**Re: PA22-024- Marysville 44th PRD – Technical Review 1
7315 / 7417 44th St NE – APN(s) 30053500303700 / 30053500303600**

This letter is provided as response to comments dated August 17, 2022. Each item has been carefully reviewed and considered and the following is a summary of how each item was addressed.

NTS COLLECTOR ARTERIAL

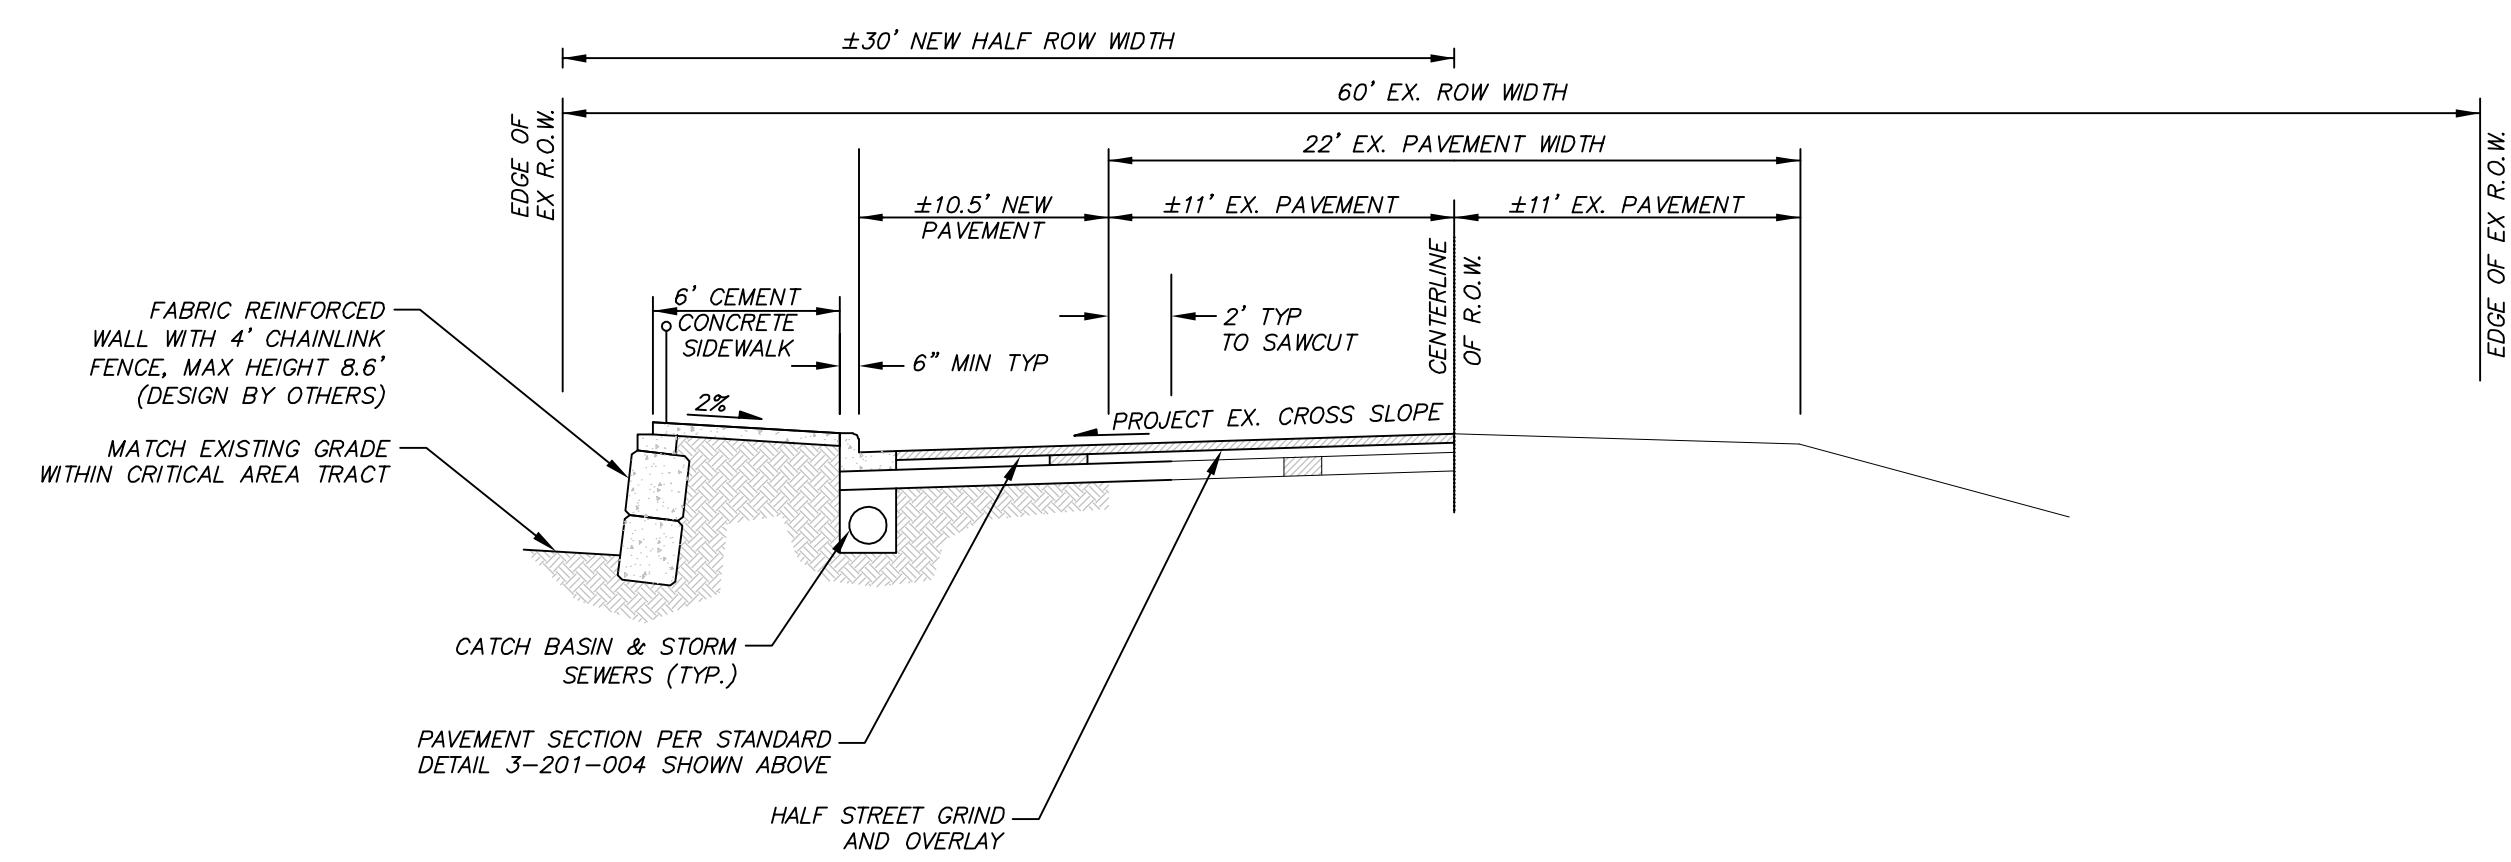
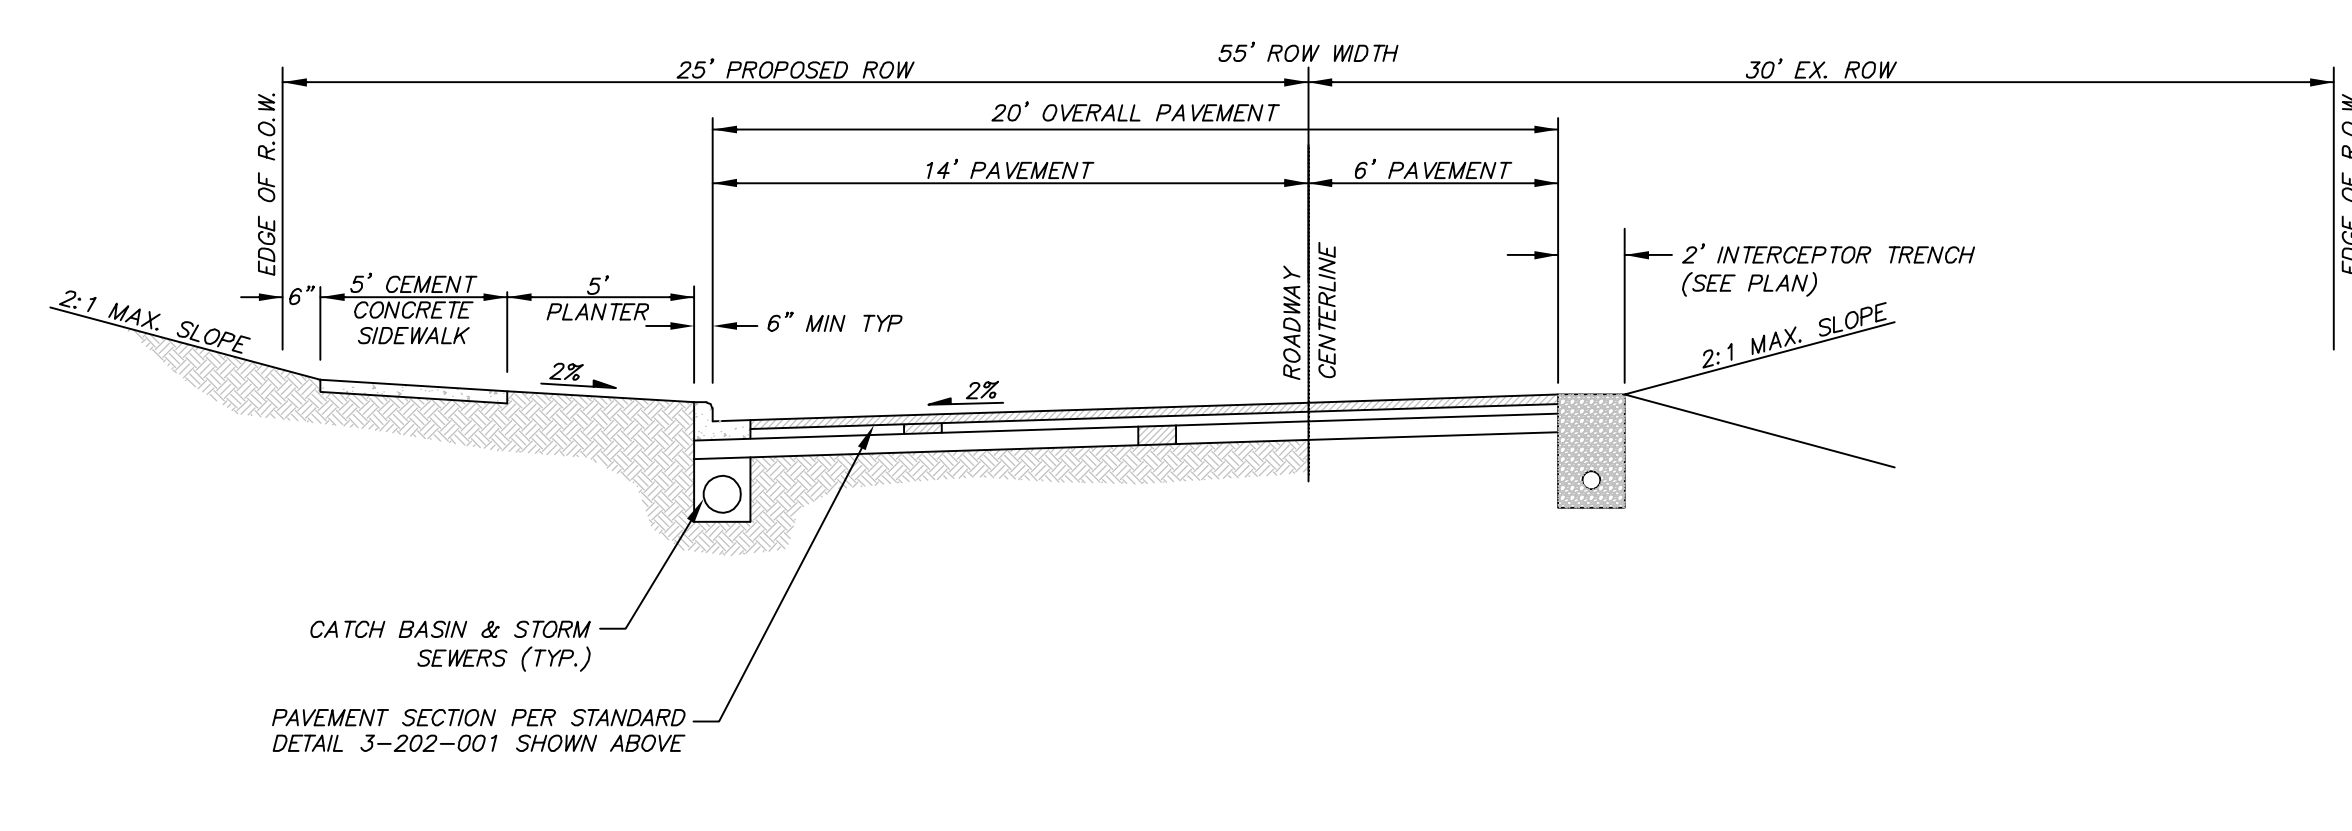
- f. Even though 75th Ave NE will only be built as a half street it still must be built per SP 3-202-001, including a planter strip, matching the development to the north.

Revised.
